Longridge Town Council

19 August 2011

Following the meeting of Longridge Town Council on Wednesday 10th of August 2011, I am directed to inform you of the Council's comments as follows:

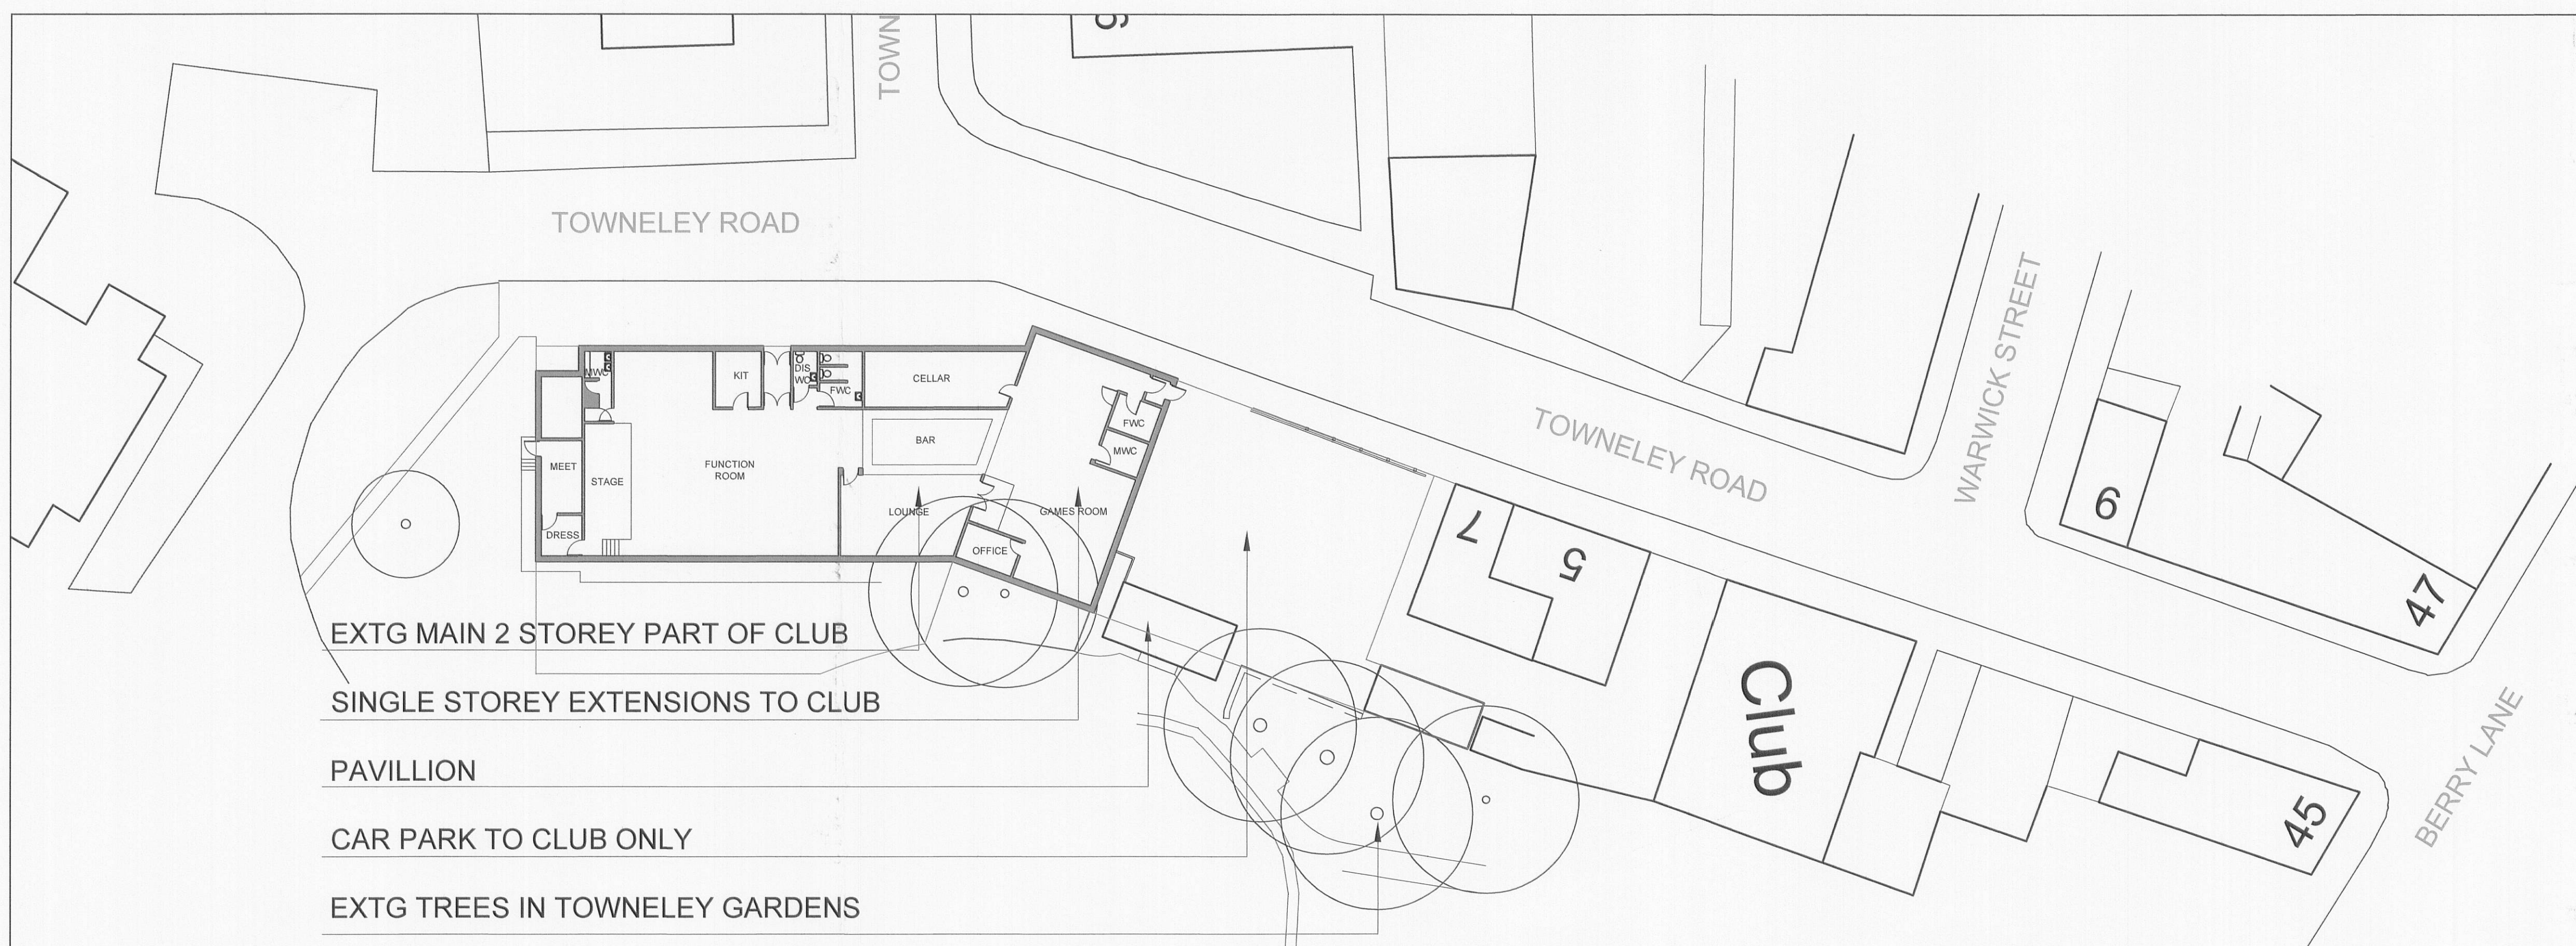
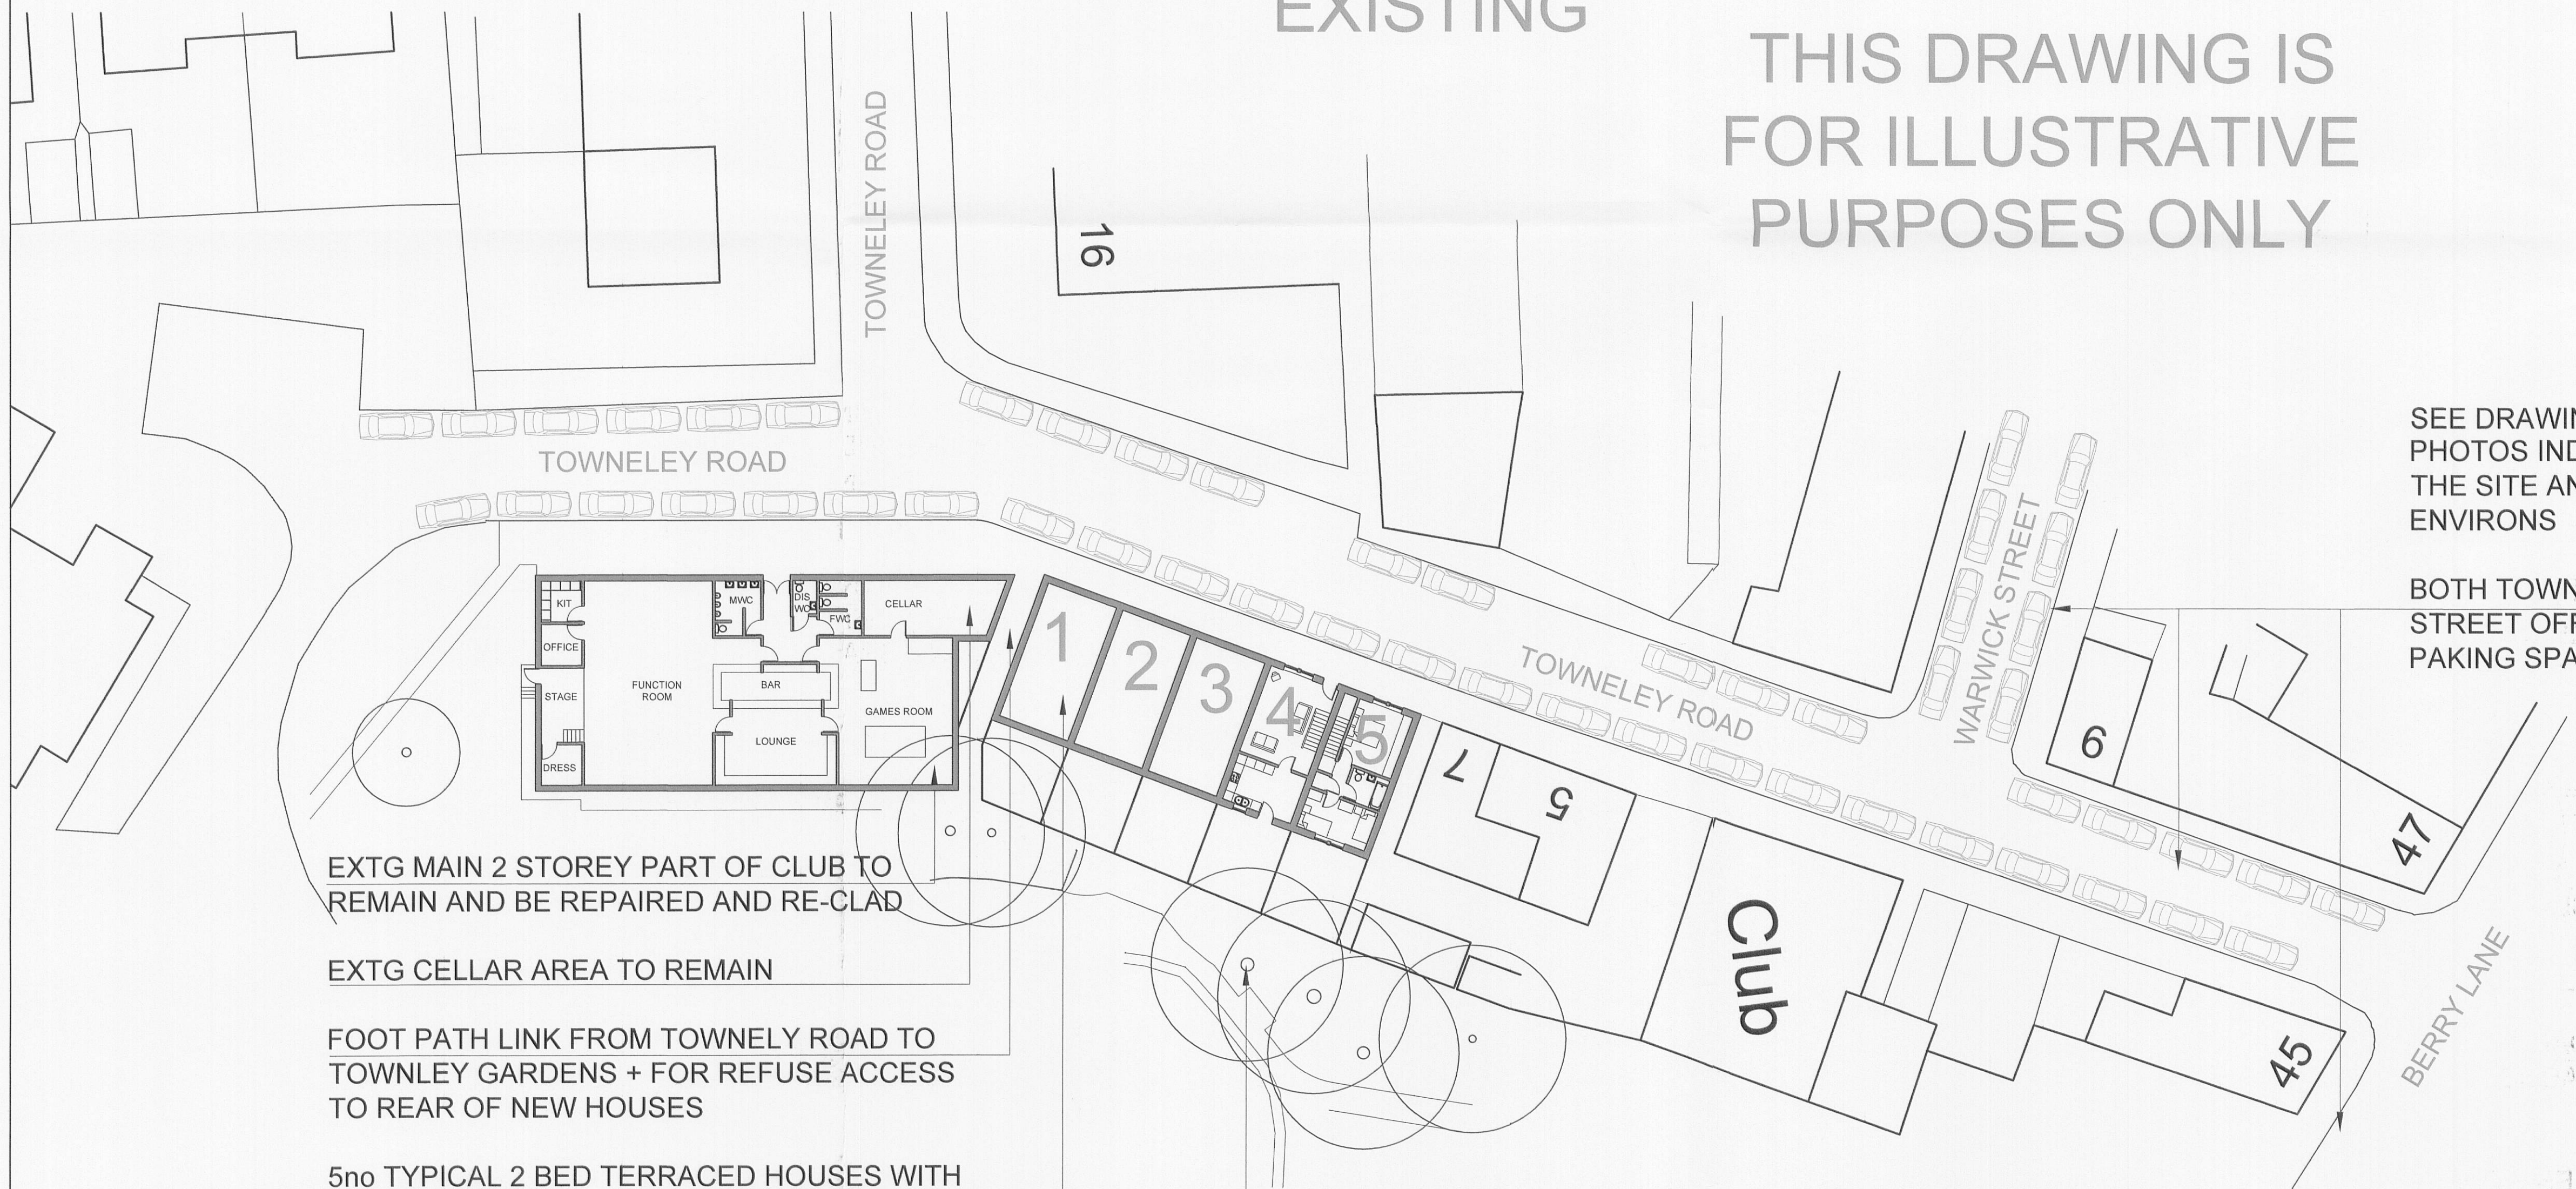
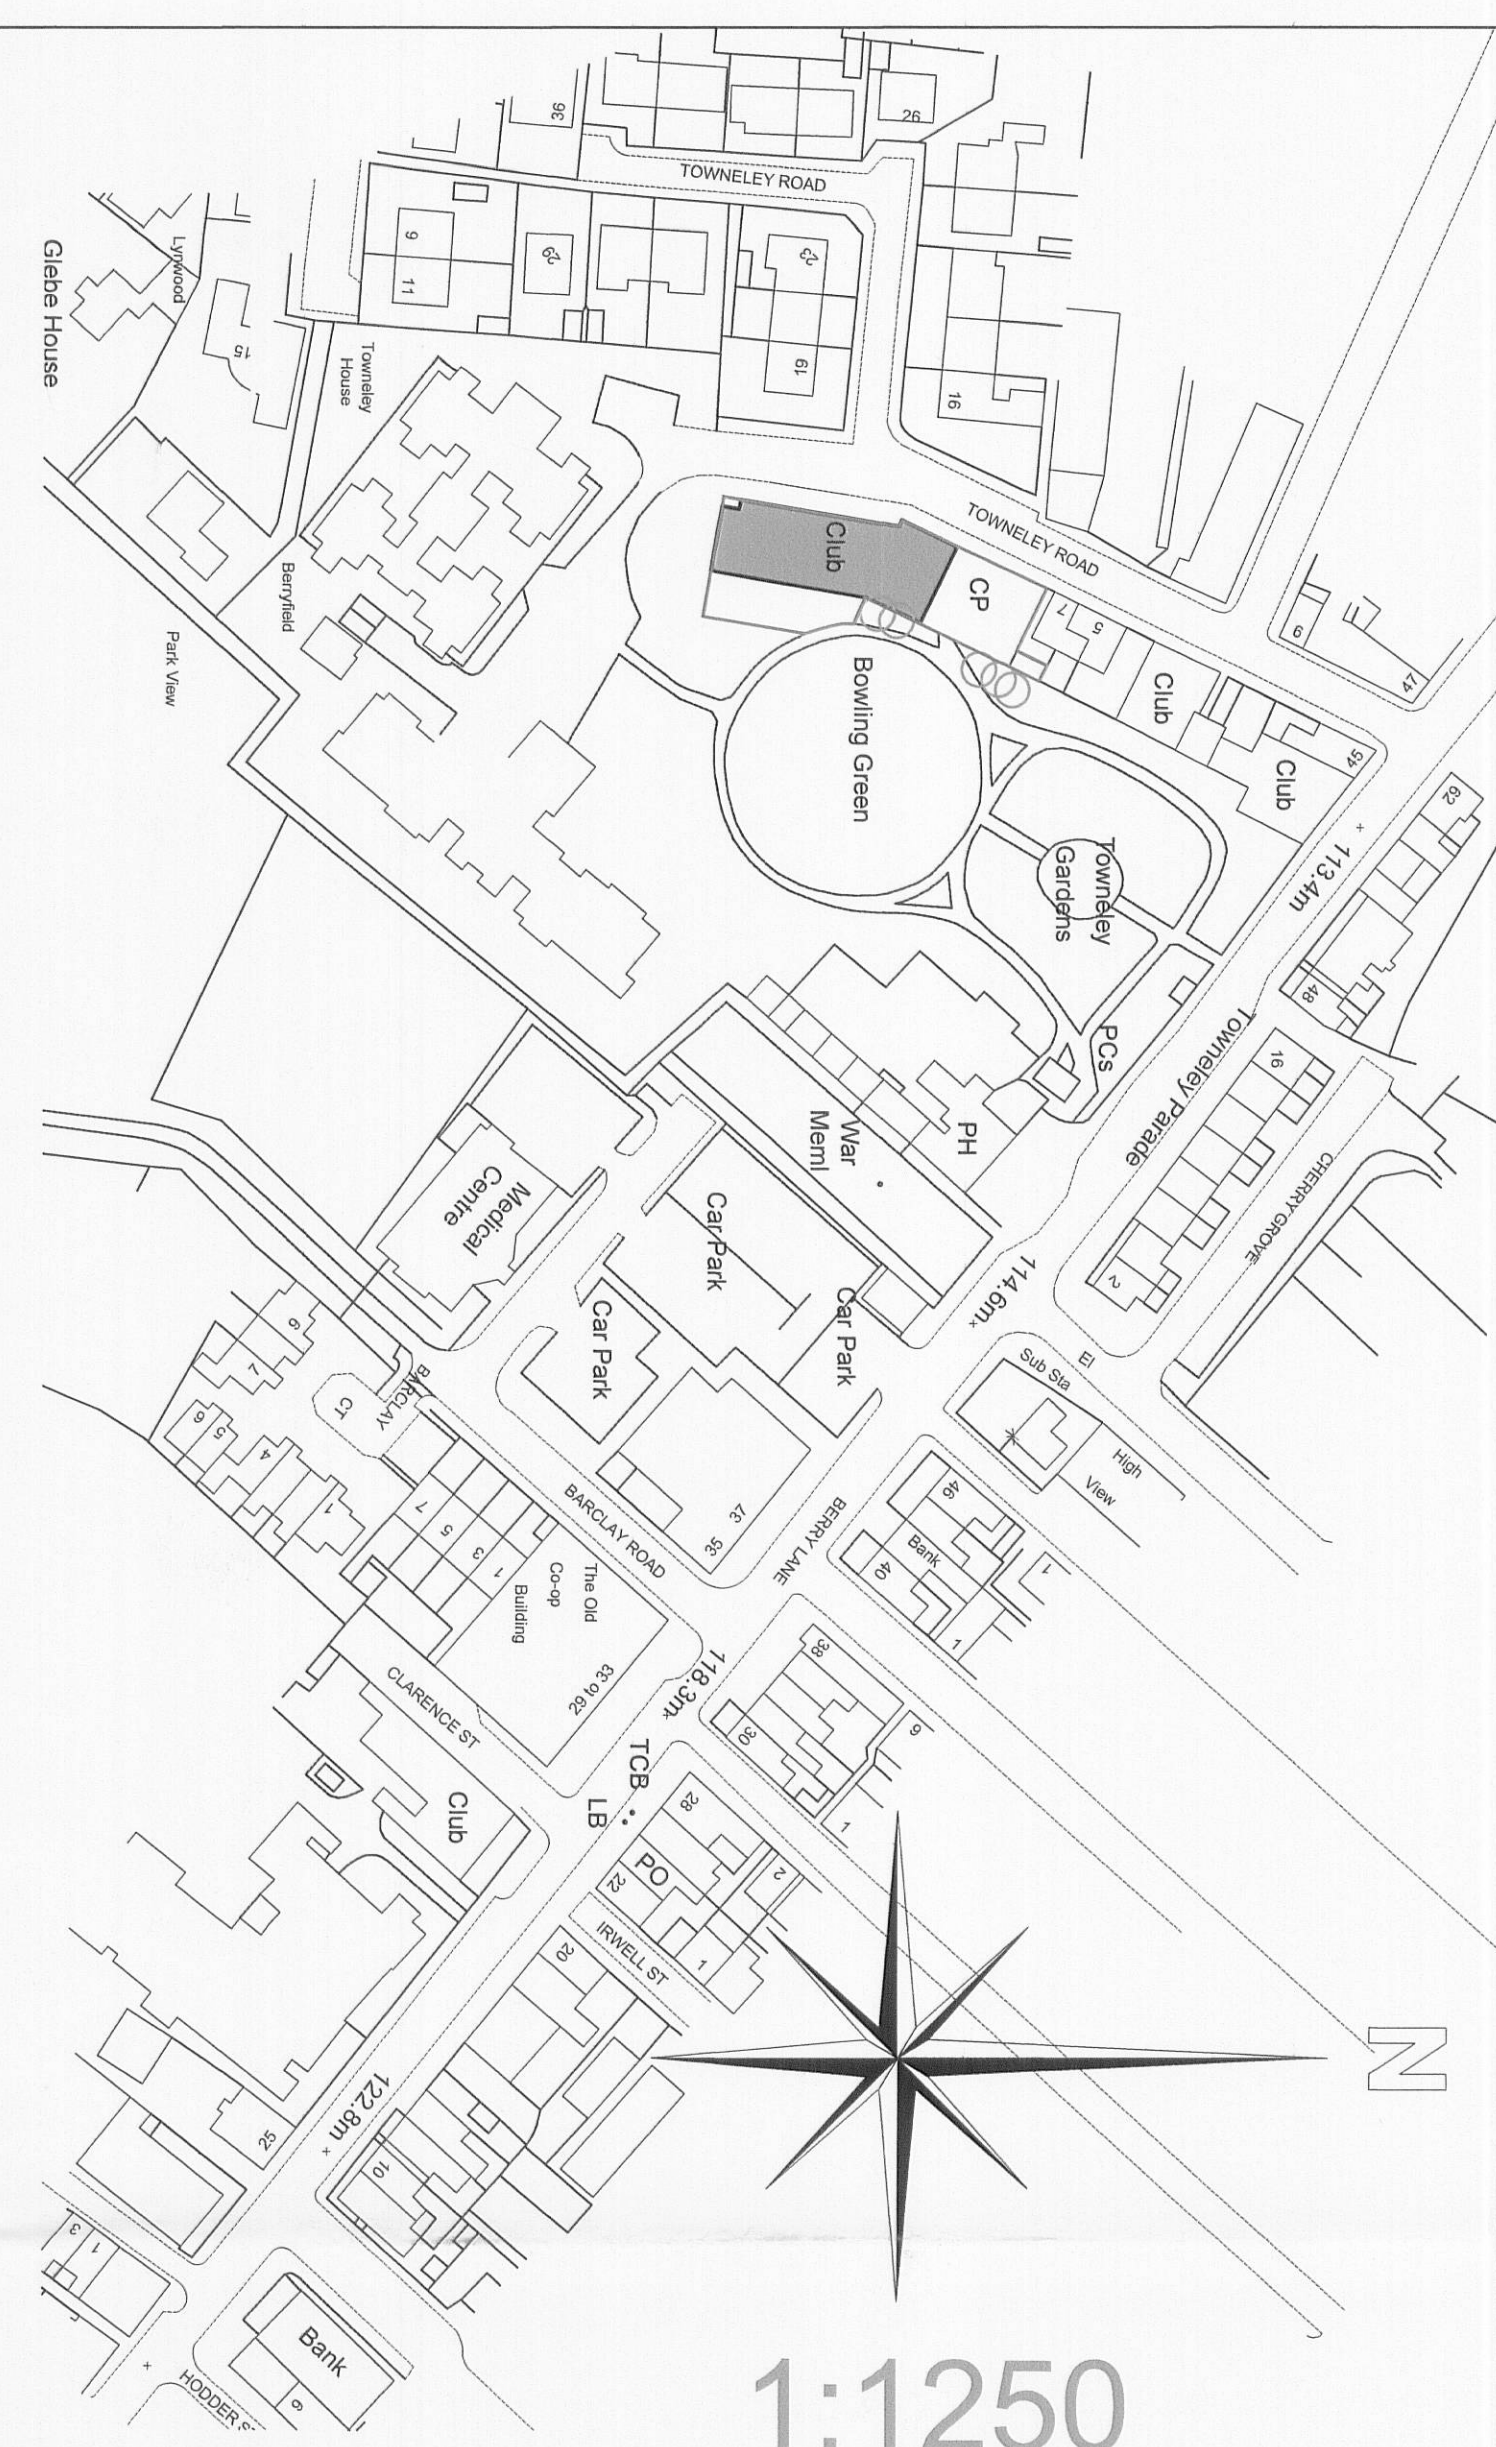
Application No.	Location
3/2011/0400	The Royal British Legion Club, Towneley Road, Longridge, PR3 3EA
Proposal	
Outline application to reduce the size of the existing Royal British Legion Clubhouse by demolition of existing single storey gable extensions (extension to the South elevation to be rebuilt). Erection of 5 no. typical terraced houses with yards on site of the existing car park and part of Clubhouse site.	
Town Council Comments	
It was resolved that the Council has no objection to this application, and welcomes the scale and type of houses proposed as these are likely to be attractive to the indigenous population of the town particularly younger people seeking a start on home ownership. Although supporting the application, the Town Council expresses concern about the implications of the increase in on-street parking that will result from this development. The Town Council, with the benefit of local knowledge, knows that parking spaces are already under pressure in this part of the town, and that traffic movements are often restricted along Towneley Road and Warwick Street. Councillors consider that car parking, and ensuring access by emergency vehicles to Park House and Towneley House are aspects that require further attention.
